Suffolk County Council (20041323)

**Revised Annex F of the Suffolk Joint LIR
(Review of Site Accesses)**

Bramford to Twinstead (EN020002)

9 February 2024

G:\BLON\7501_europe_jacobs.com\projects\UNIF\Projects\B2416601 - Bramford to Twinstead EIA TA Drawings\Accesses\2023-12-20.dwg - 20/12/2023 16:50:37 - F-DAP4 - GHAFPAUK

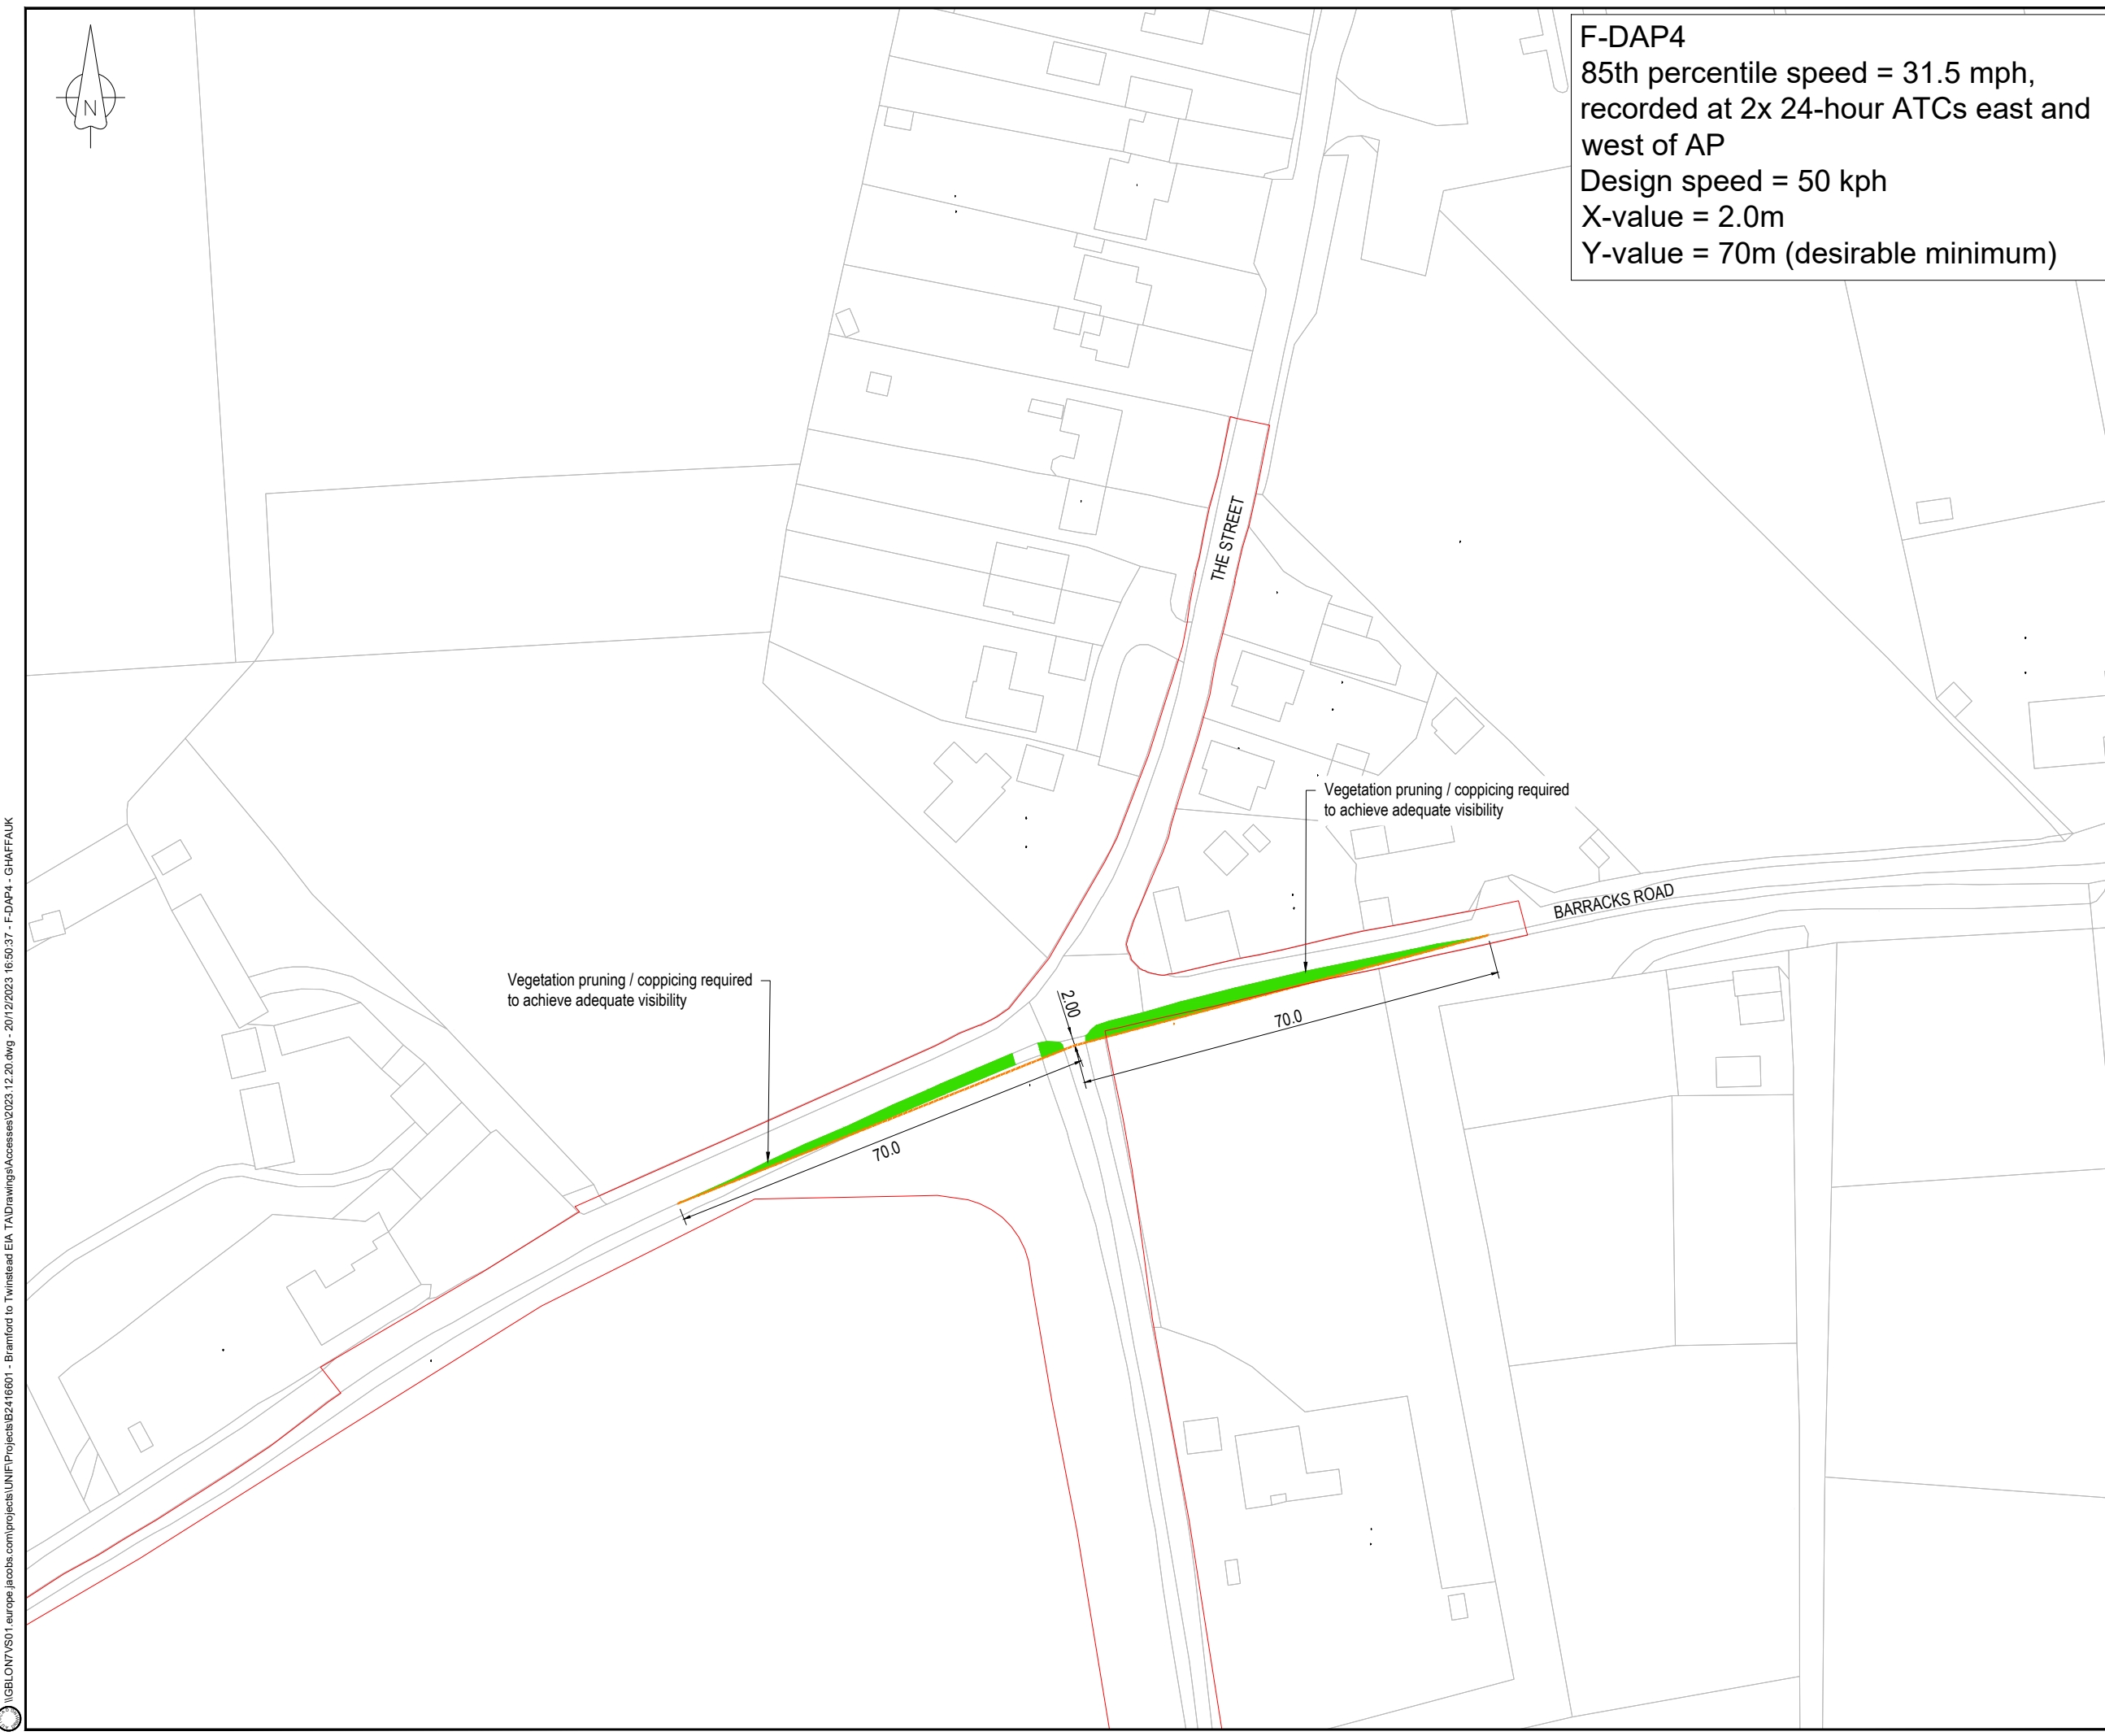
F-AP10	Bures Road (not Rose Green)	Assington	C733	Sheet 17	private road	4.8	30	n/a	90	no	yes	Temporary	586	0	544	n/a	subject to 30 limit	90m	2x70m	LCC75	31	7am-7pm	Junction of The Street, Barracks Road and Bures Road.							
F-DAP4					new	3.7	30	n/a	90	no	no?	Temporary	328	0	454								Note 85%ile speed 28 / 35mph week 1 / 2							
F-AP12					track	4.4	60	n/a	215	no	yes	Temporary	48	0	20															
F-DAP5					new	4.1	60	n/a	215	no	yes	Temporary	320	0	434															
F-AP13	Wormingford Road (not Smallbridge Entry)	Assington	U8607		new	2.8	60	n/a	215	no	no	Temporary	60	0	32	n/a	30mph	90m		Not available	n/a	7am-7pm								
F-AP14					field	3.9	60	n/a	215	no	yes	Temporary	464	0	562								n/a	30mph	90m		LCC17	34	7am-7pm	
G-AP2					field						yes	Temporary	456	0	992															
G-AP1	hardstand	4.6	60	n/a	215						no	no?	Temporary	696	0	1476														
G-AP3	St Edmunds Hill	Bures St Mary	B1508	Sheet 20	new	4.9	40	n/a	120	no	yes	Permanent	13400	0	4662	SO / STGO	30mph	90m		LCC15	45	7am-7pm	Poor compliance with speed limit Traffic calming necessary for temp speed limit

Drawing title
**F-AP4: B1068 Stoke Road, Leavenheat
 Proposed Visibility Splay
 Concept Design
 Sheet 1 of 1**

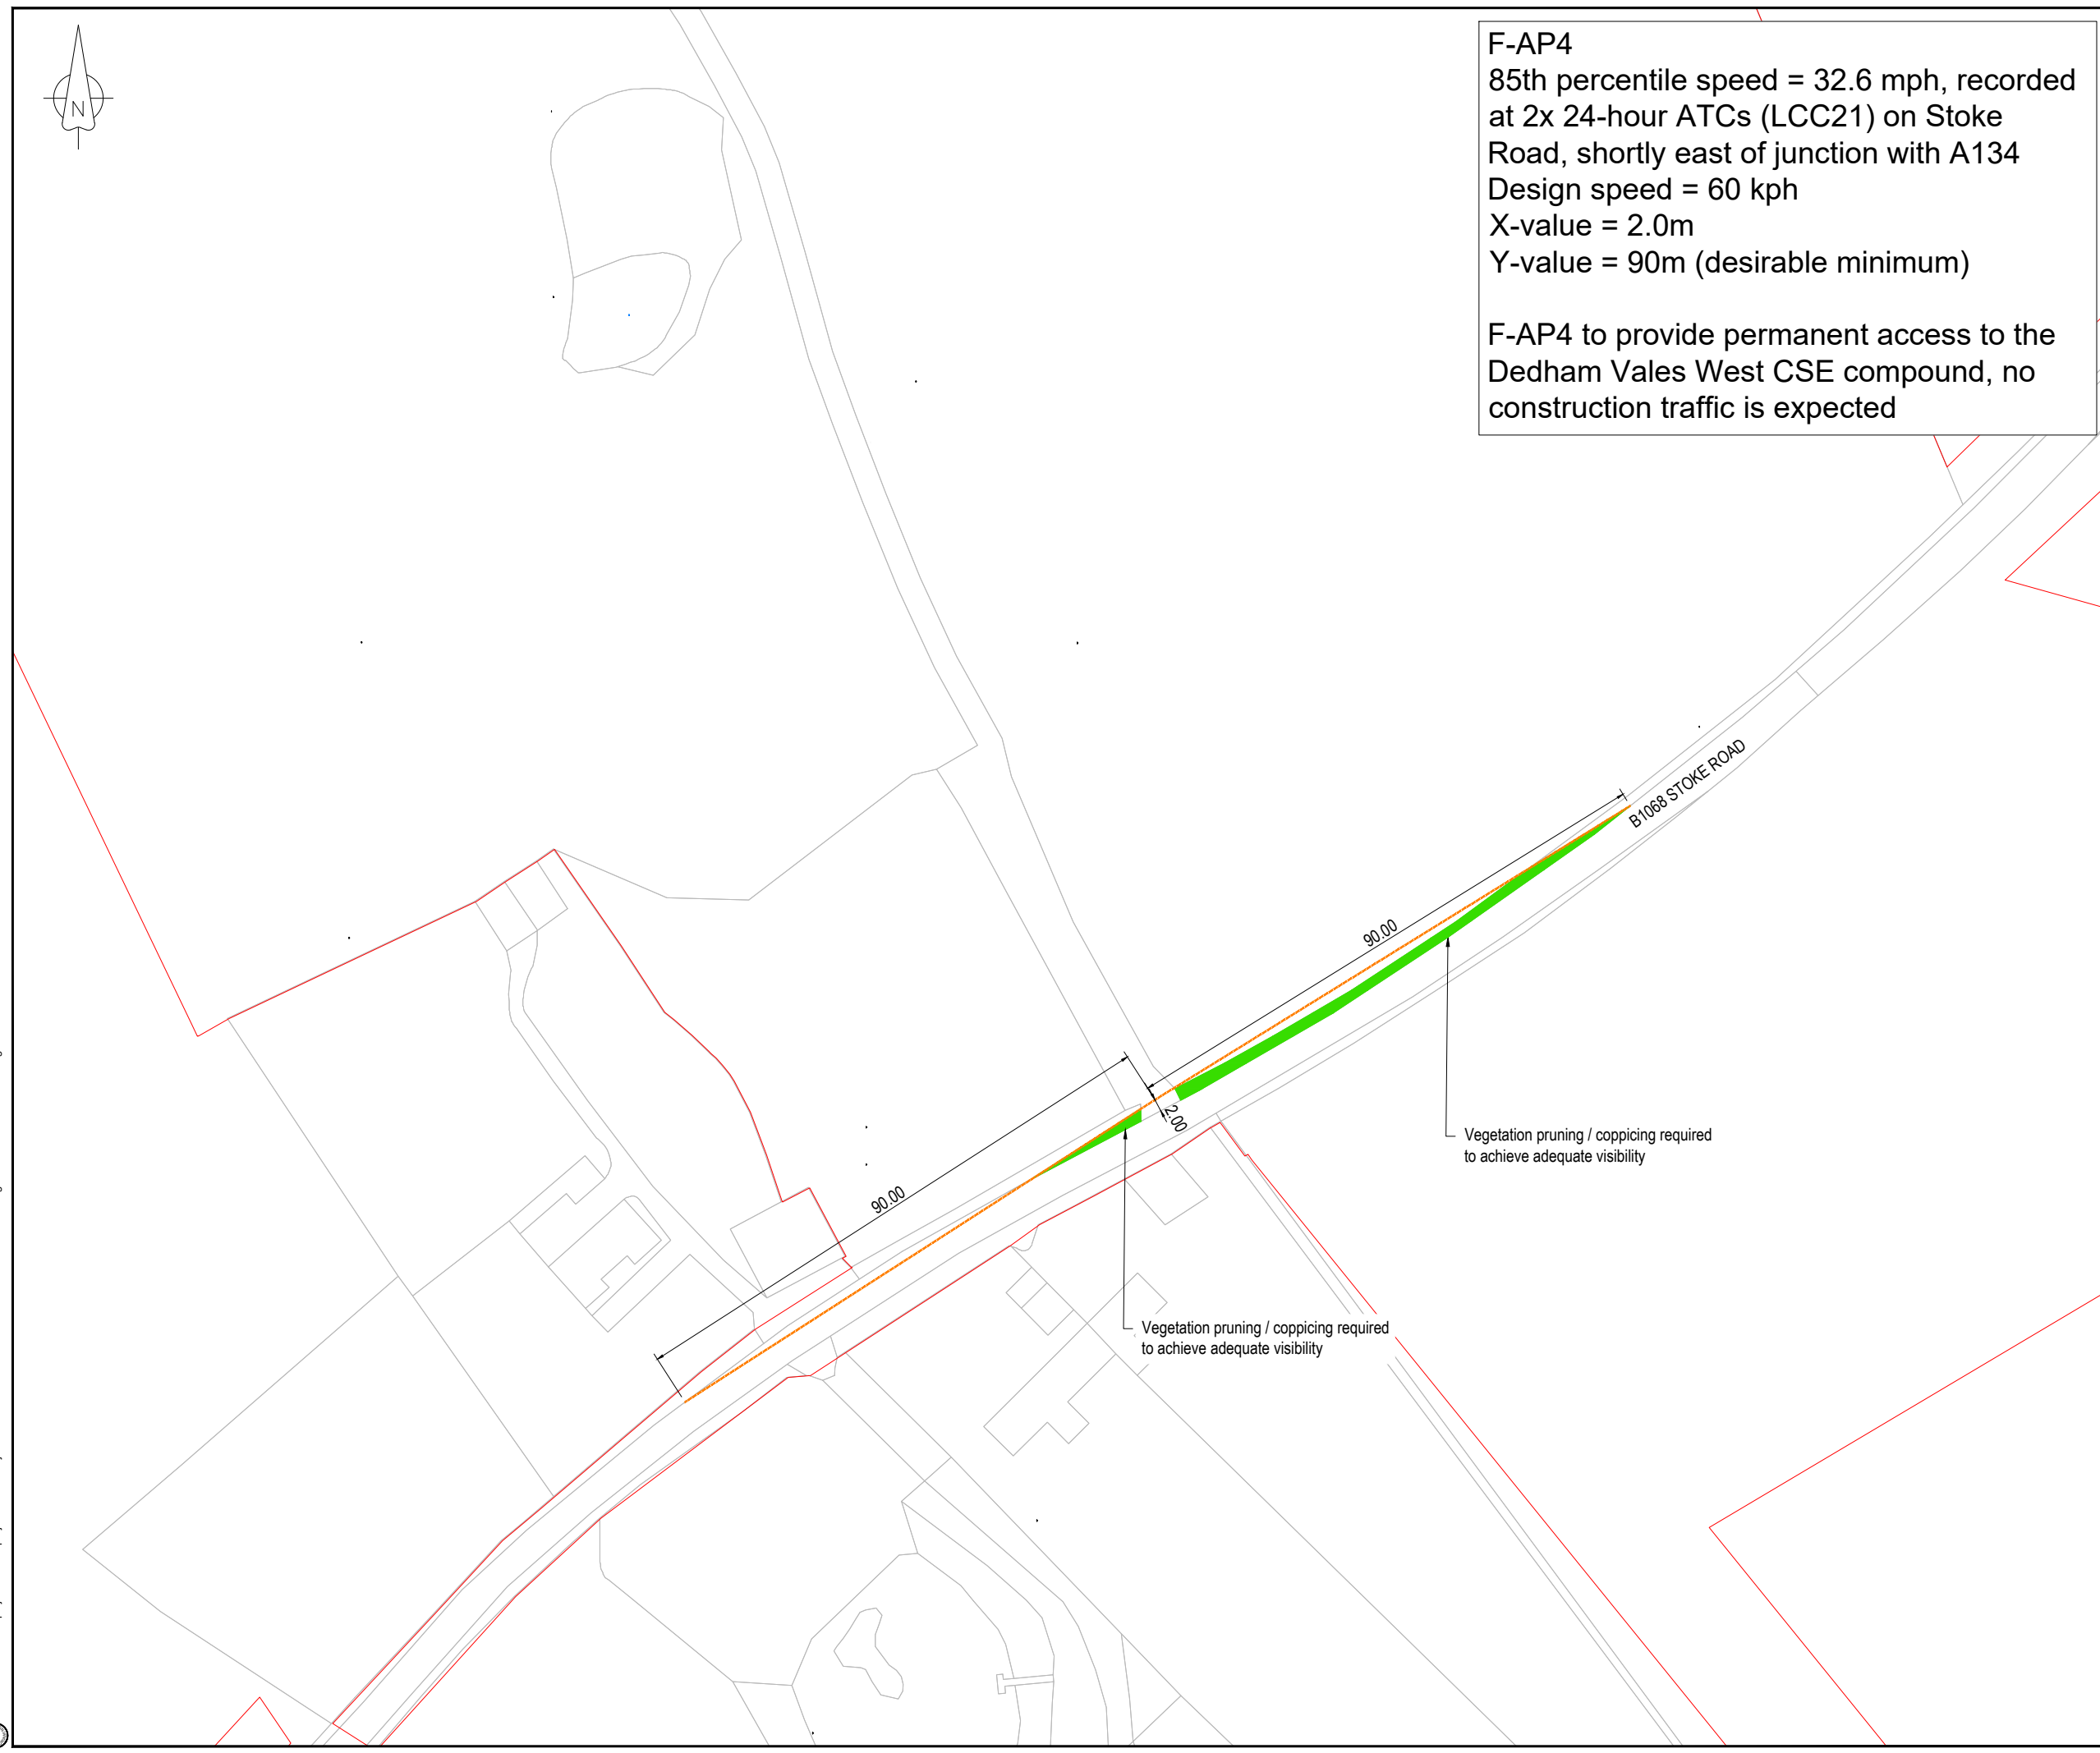
F-AP4	Stoke Road	Leavenheath	B1068	Sheet 15	field	4.8	60/30	n/a	215/90	no	yes	Permanent	0	0	0			2x70m			Adjacent to 30 limit / derestriction.									
F-AP5	Nayland Road (not Colchester Road)	Leavenheath	A134	Sheet 15	new	5.5	40	n/a	120	no	yes	Temporary	12550	0	12088	STGO/SO	30mph	90m		LCC23	49	7am-7pm	LC23 some way from access							
F-AP6					field						7.2	40	n/a	120	no								yes	Temporary	60	0	32	Poor compliance with speed limit. Traffic calming necessary for temp speed limit		
F-DAP2					new						5.4	60	n/a	215	no								yes	Temporary	54550	0	27300	7am-7pm		
F-AP7	Colchester Road	Assington	A134	Sheet 16	new	3.3	60	n/a	215	no	yes	Temporary	708	0	942	n/a	30mph	90m		LCC19	31	7am-7pm	LCC close to junction							
F-AP8	Nayland Road (not High Road)	Assington	U8611		field	3	60	n/a	215	no	yes	Temporary	588	0	720															
F-AP9					field	3.5	60	n/a	215	no	yes	Temporary	132	0	64
